SCOPING OPINION:

Heckington Fen Solar Park

Case Reference: EN010123

17 February 2022

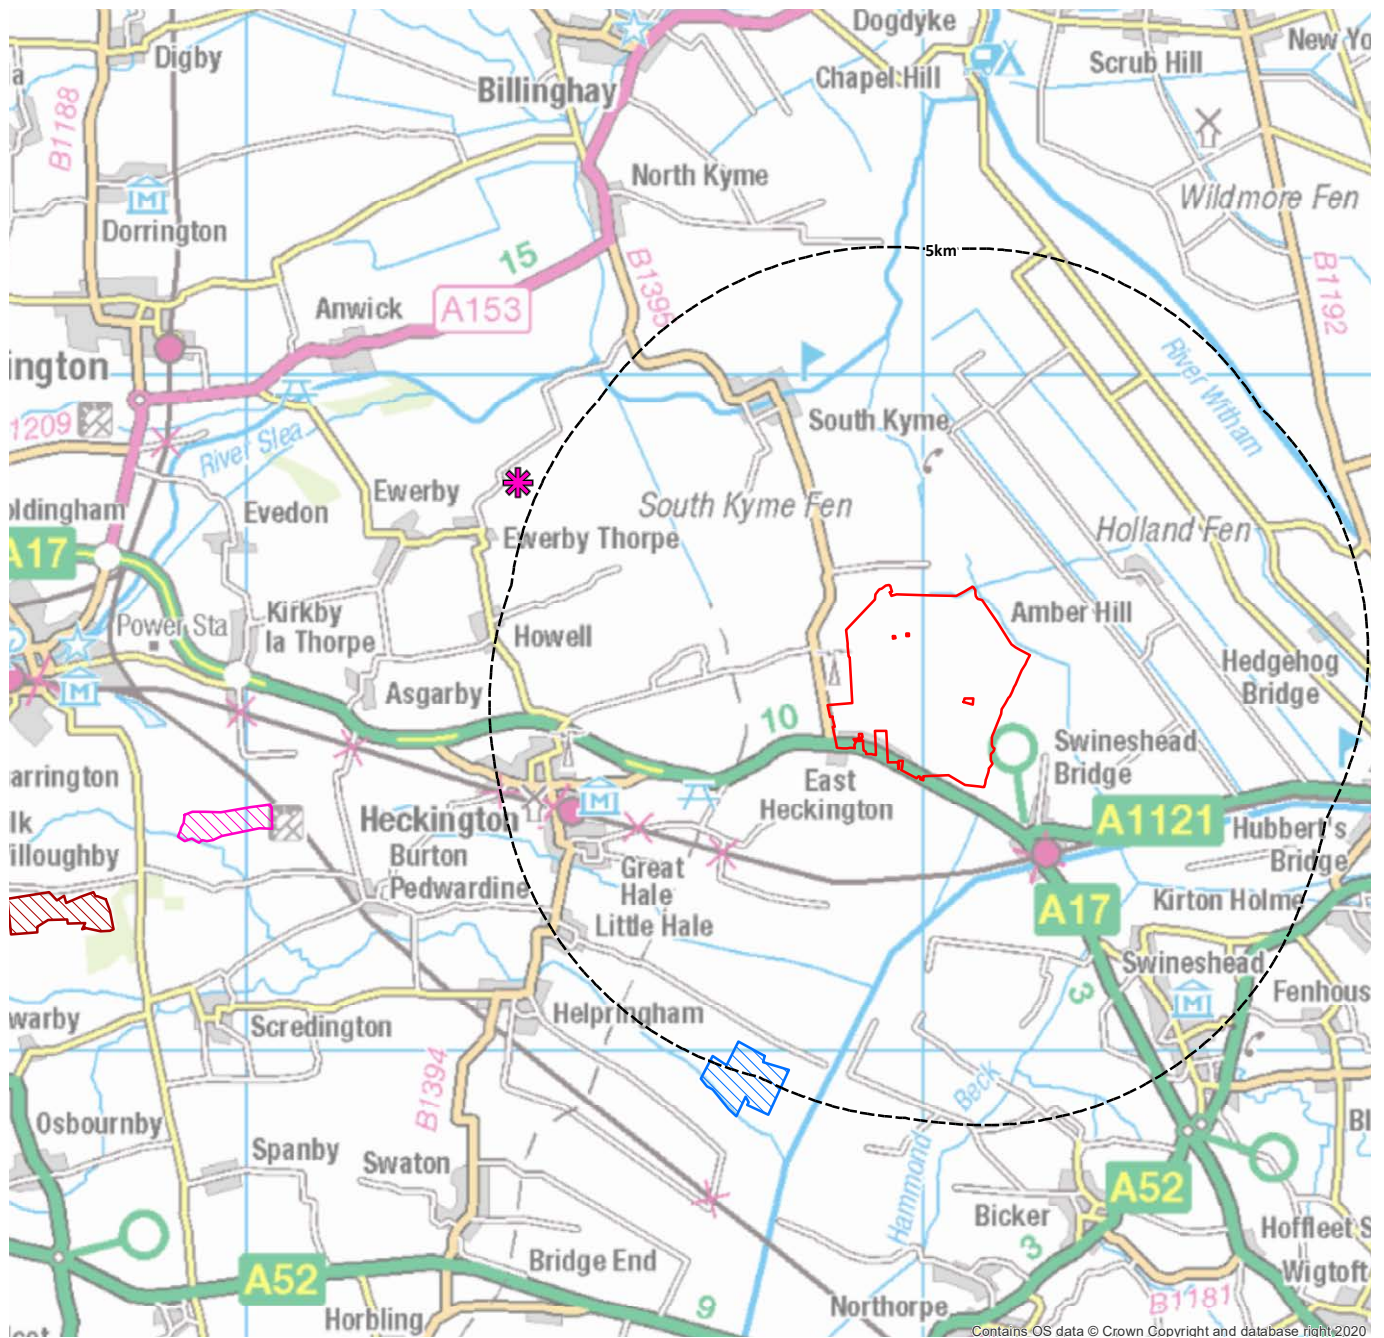
2.2.3	Figure 4	Cumulative Impact Assessment	Figure 4 depicts the 5km search area used for the cumulative impact assessment however this shows the main energy park site only and not the cable route and works at Bicker Fen substation, which also form part of the Proposed Development. The search area should relate to the whole development.

**FIGURE 11: ENERGY PARK TOPOGRAPHY PLAN**

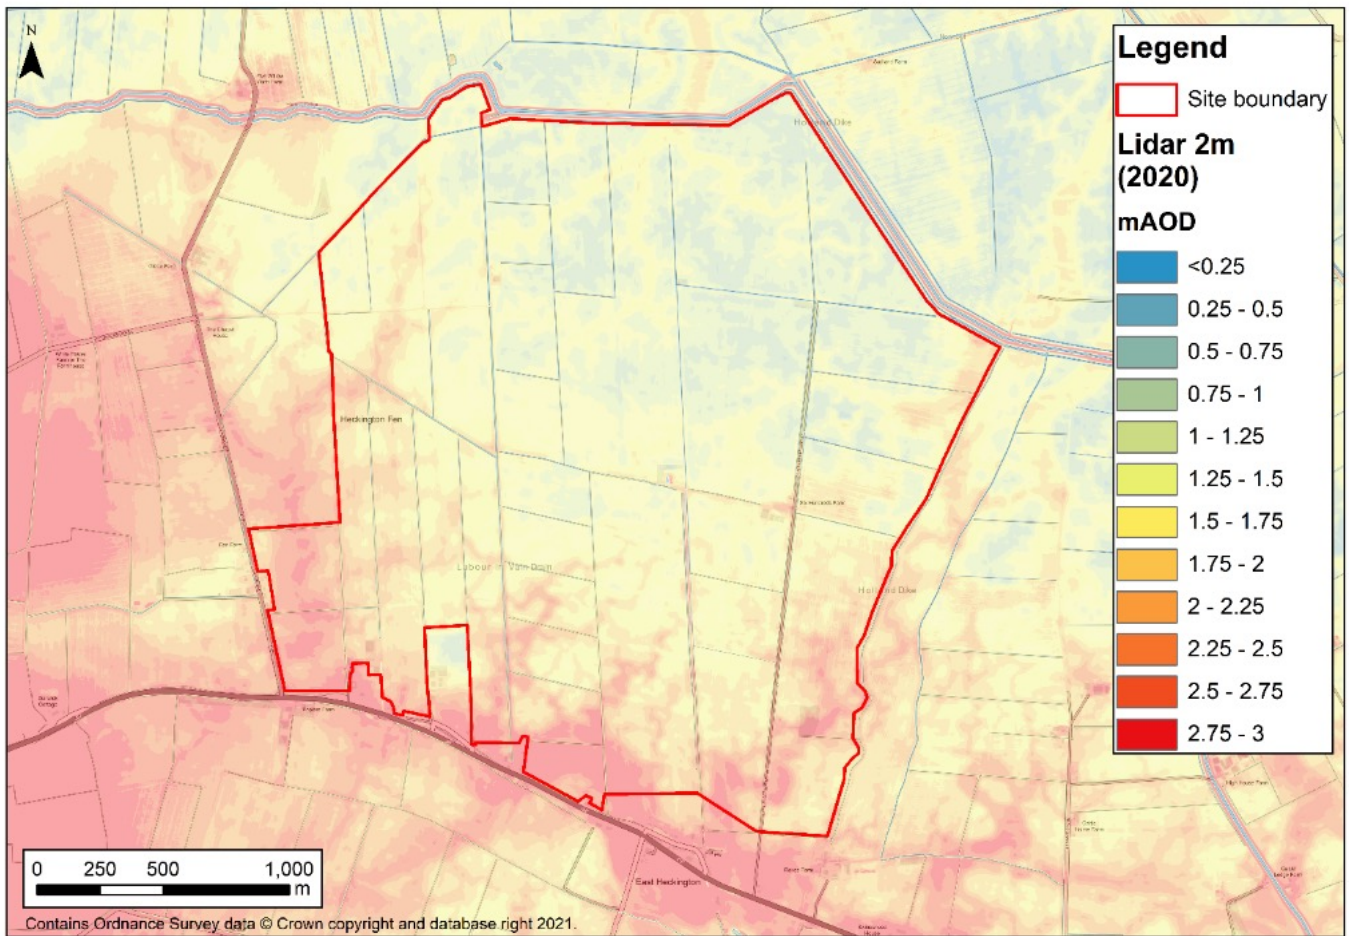
3.3.3	Paragraph 9.3 and Figure 11	Study area	<p>Paragraph 9.3 refers to Figure 11 to demonstrate the study area, however this figure only shows the site boundary (redline boundary) and topography data; it is unclear whether the site boundary, figure extent or other area represents the study area.</p> <p>The ES should clearly explain and justify the study area used in the assessment.</p>
